Please ask for: Mrs D Johnson
Email: daun.johnson@arun.gov.uk
Telephone: 01903 737762
Our Ref: FP/84/21/PL
Your Ref:
Date: 16th April 2021

Application for Planning Permission

Development: 1 No. additional self-contained beach hut with sleeping accommodation. This site is in CIL Zone 4 (Zero Rated) as other development.
Location: Land Adjacent To The Gun Post Clyde Road Felpham PO22 7AH

Floor Plans

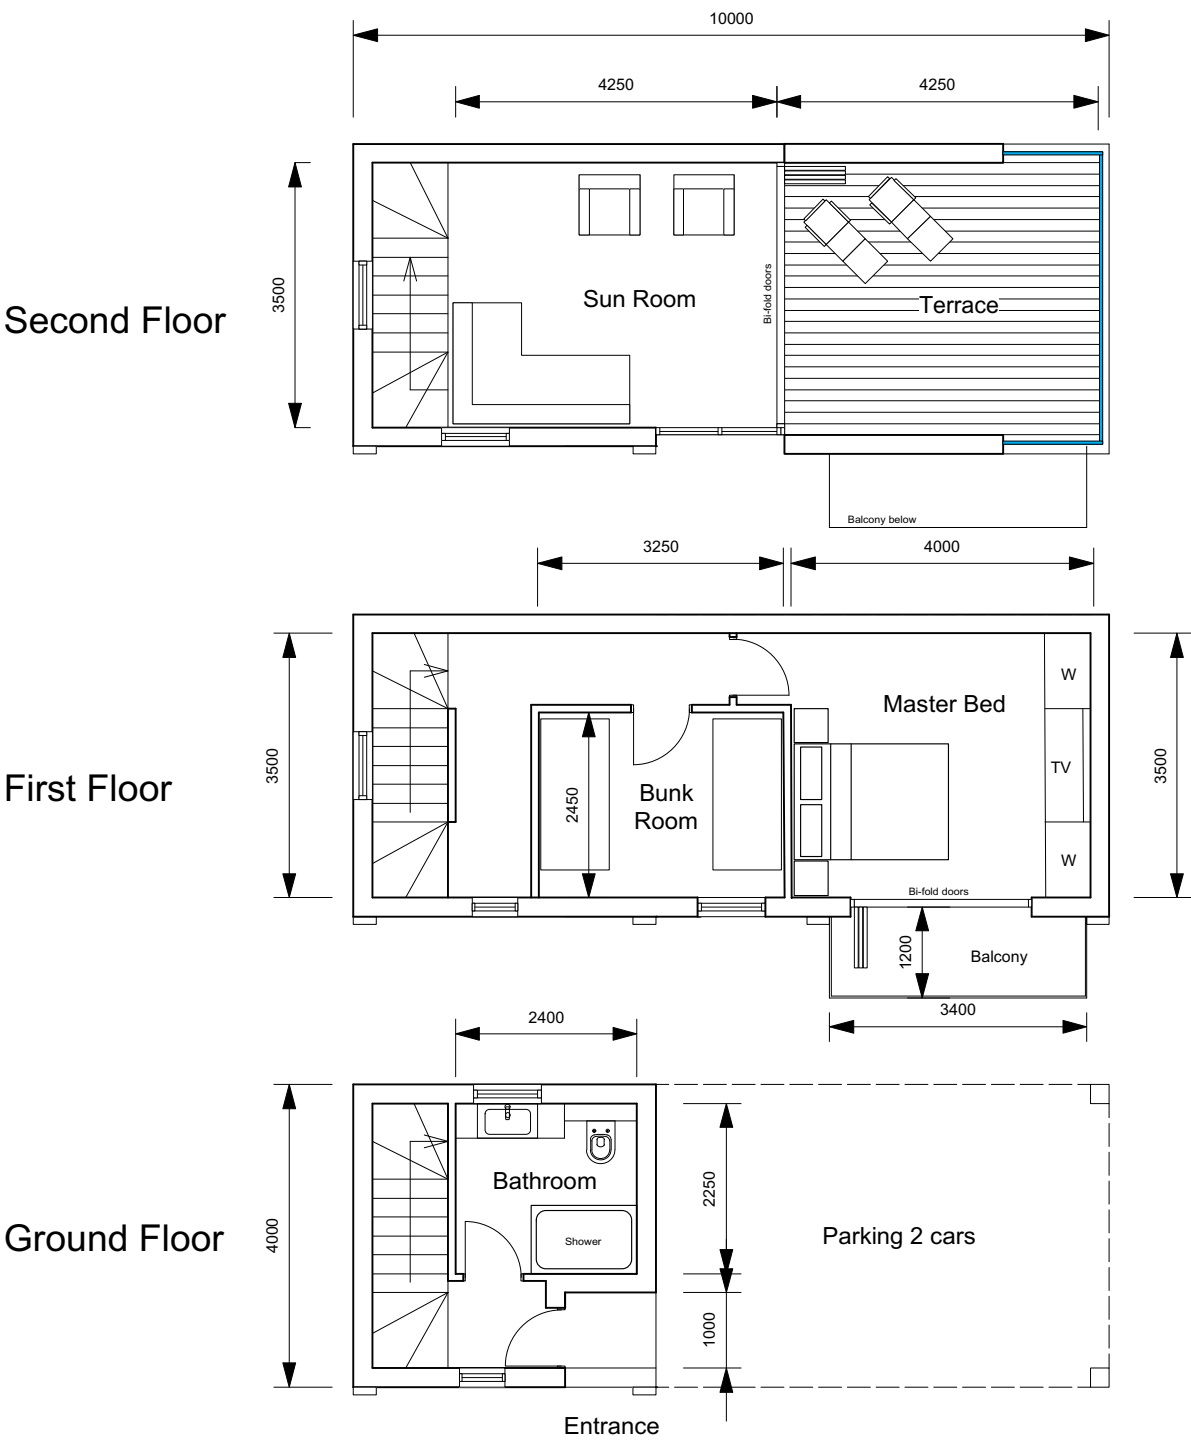
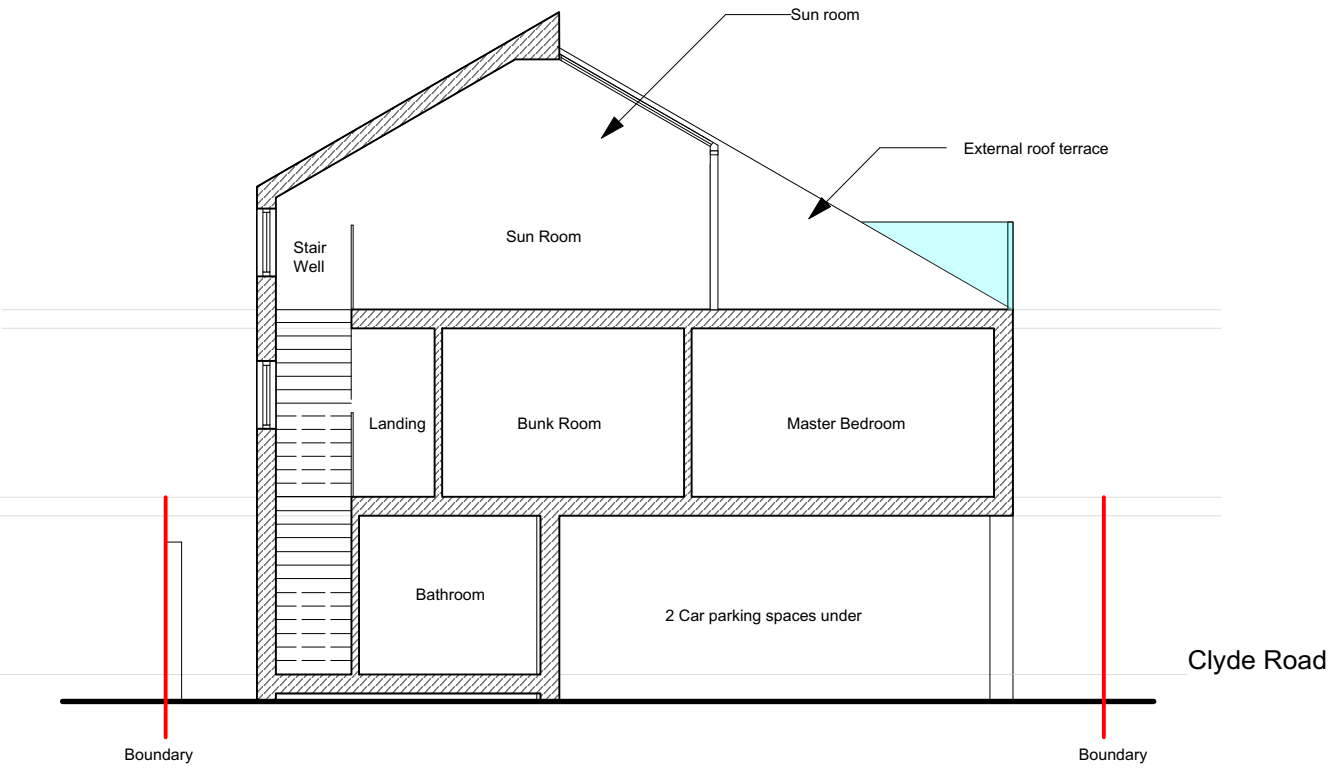
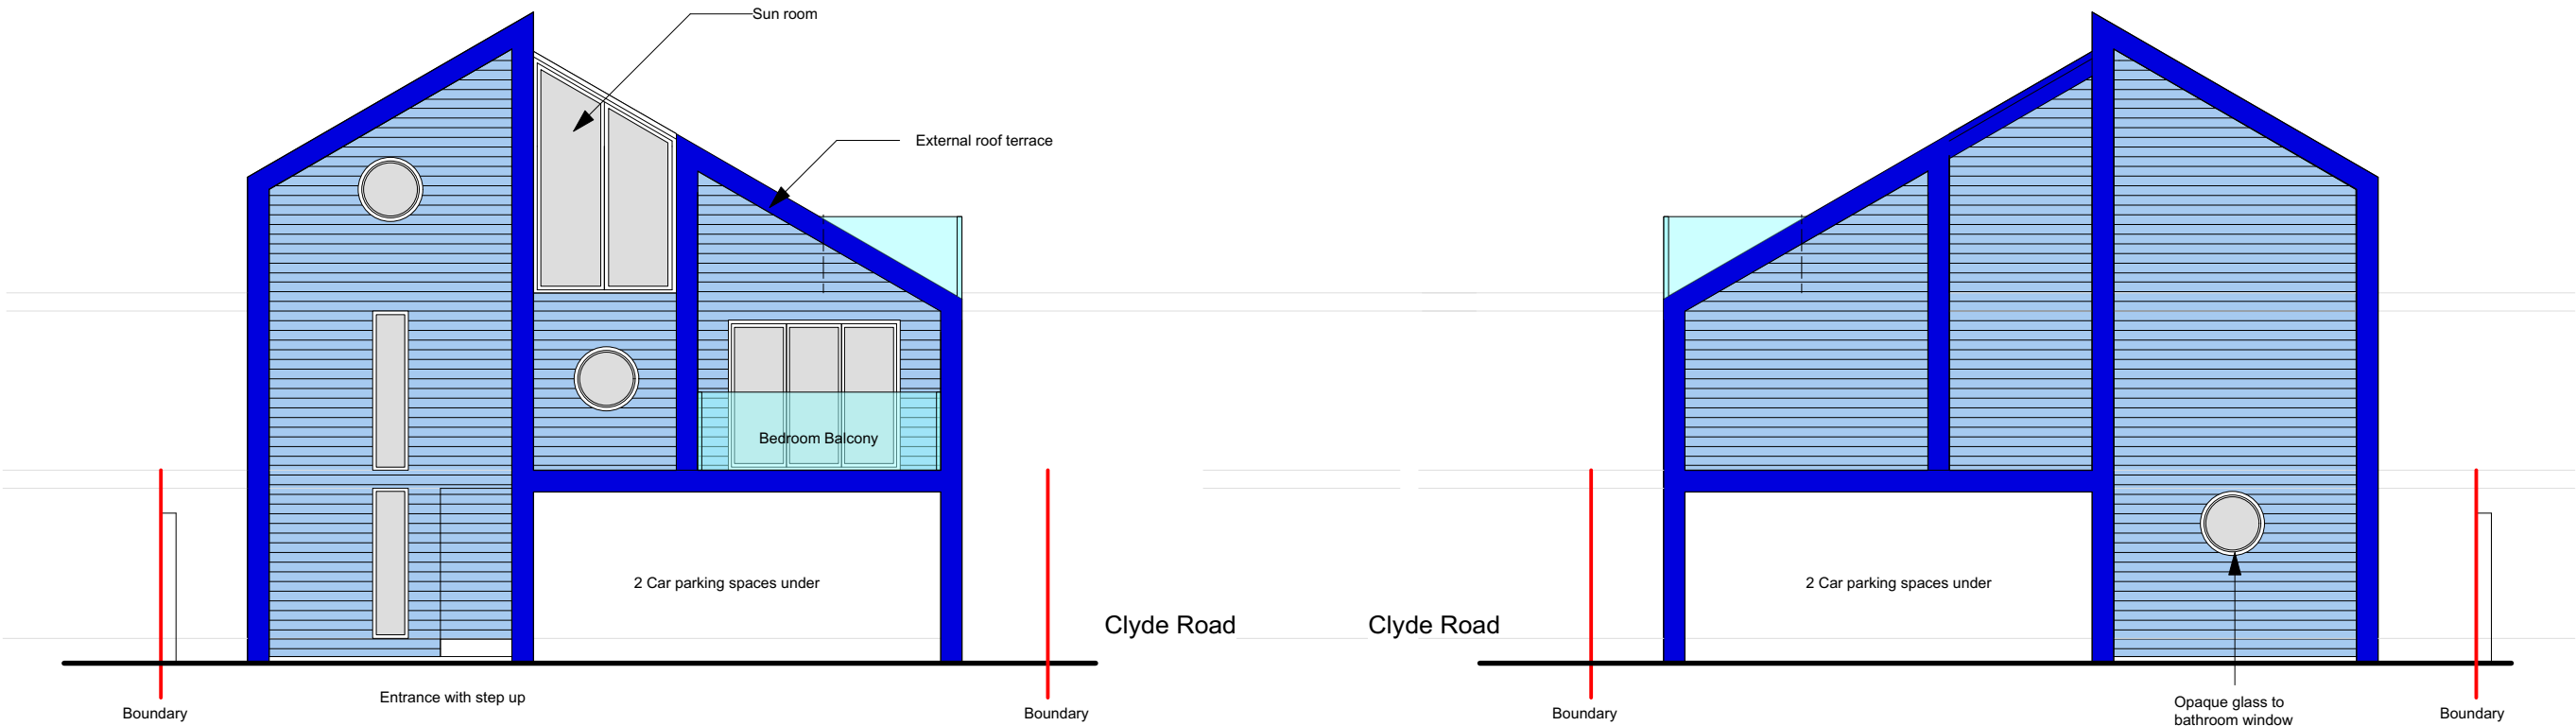
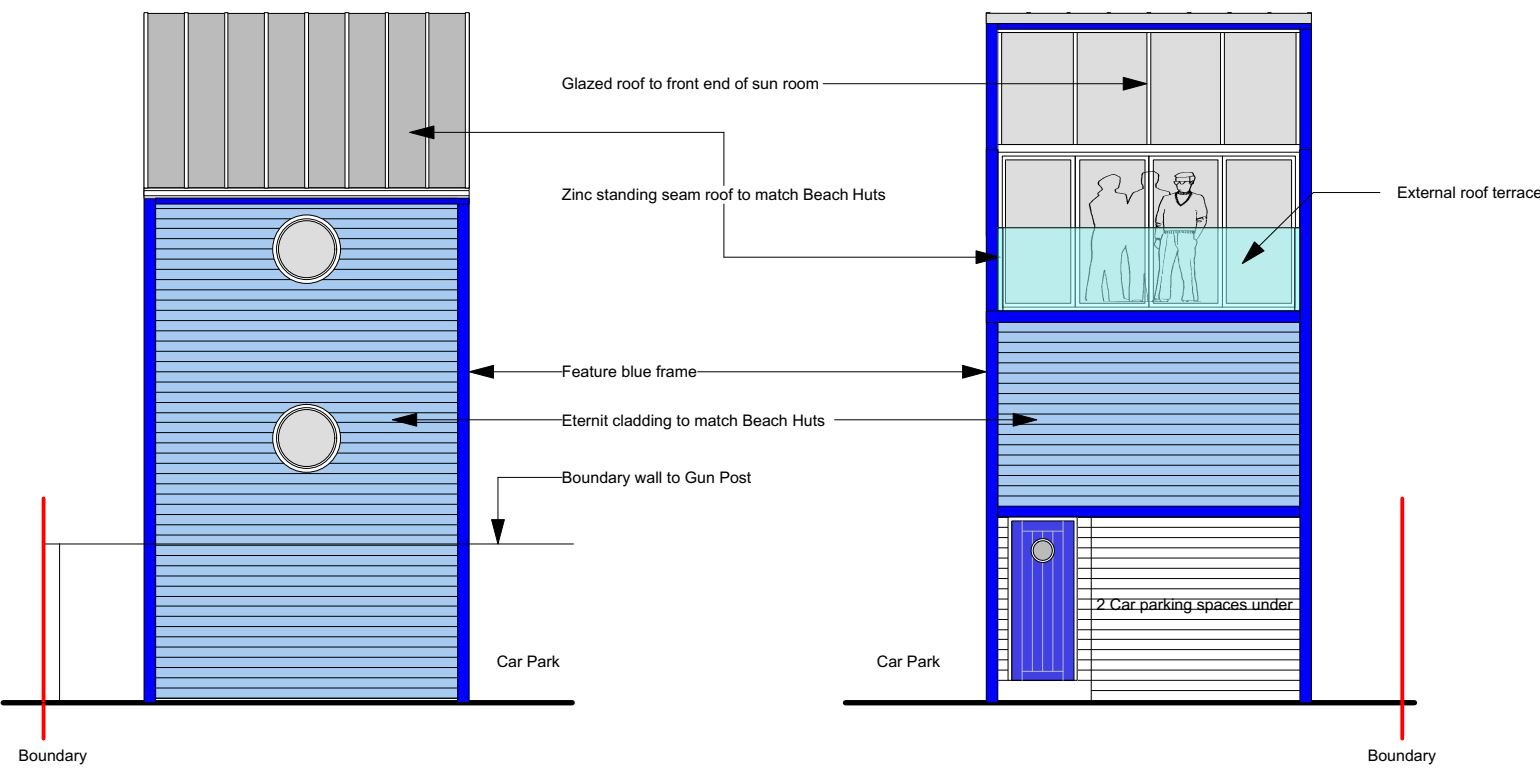
The ground floor plan and East elevation do not accord. Please amend accordingly.

The first floor and South elevation do not accord. Please amend accordingly.
